RESPONSE TO PLANNING APPLICATION 20/01127/F

HATCH END OLD POULTRY FARM, MIDDLE ASTON ROAD, MIDDLE ASTON: DEMOLITION OF EXISTING BUILDINGS. ERECTION OF REPLACEMENT BUSINESS UNITS, ANCILLARY HUB AND ASSOCIATED EXTERNAL WORKS.

ferguson mann architects			
Job Title The Hatchery, Middle Aston		Drawing Title Unit Details - Hub	
Client Middle Aston Limited			
Scale 1:100 @ A3	Date 05.06.19	Dwn RG	Chckd AK
Job No 10949	Drawing No PL 138	Rev

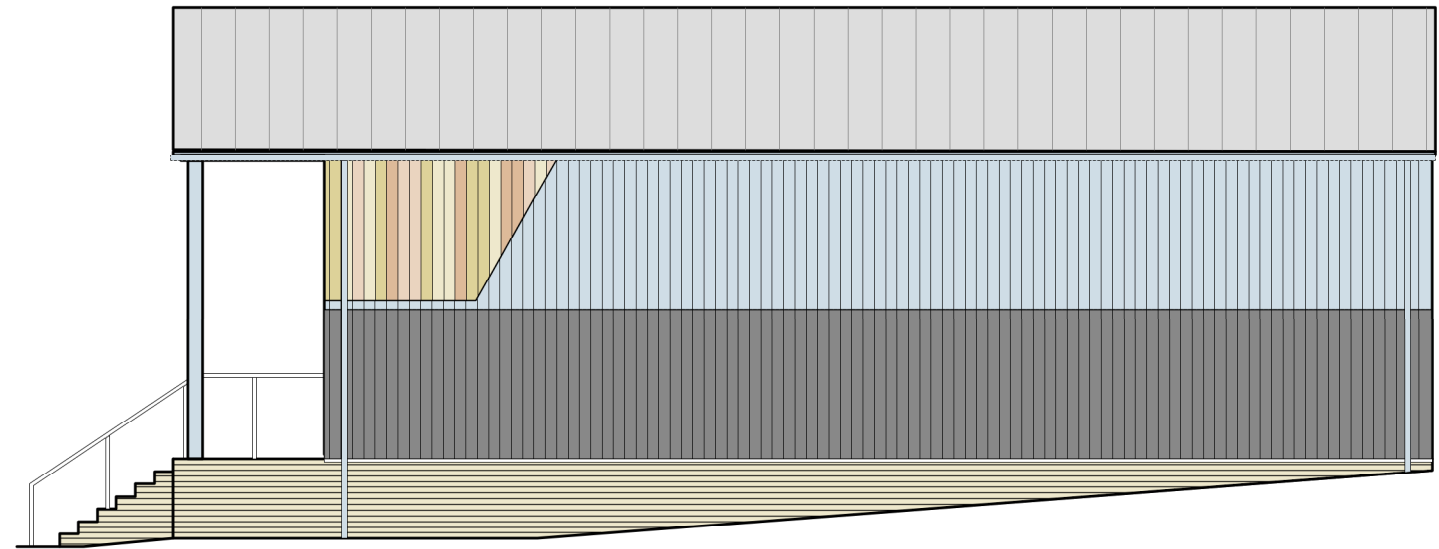
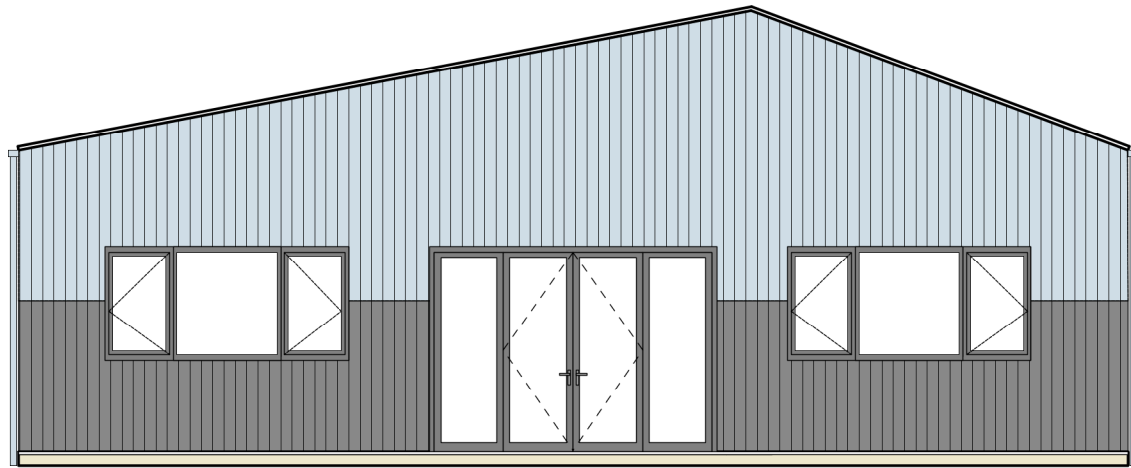
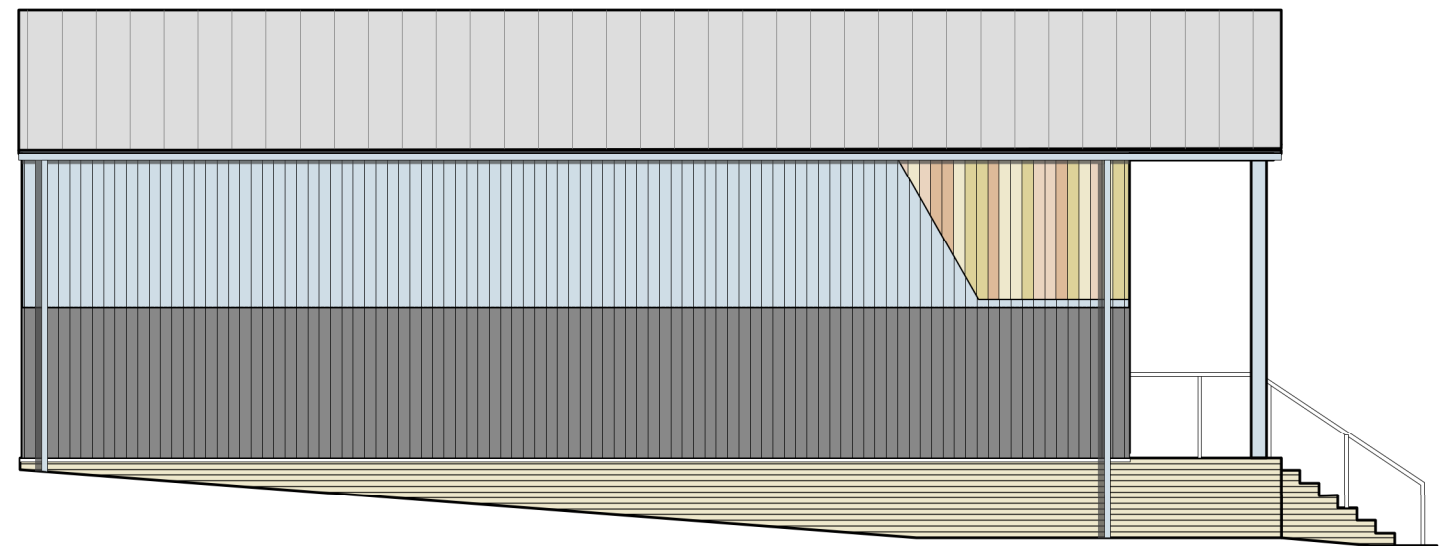
The proposed building at the entrance to the site (“the Hub”) is strangely asymmetrical and unsuitable for its key location. Replacing the existing clocktower on the new entrance building could provide a welcome connection to the original use of the site.
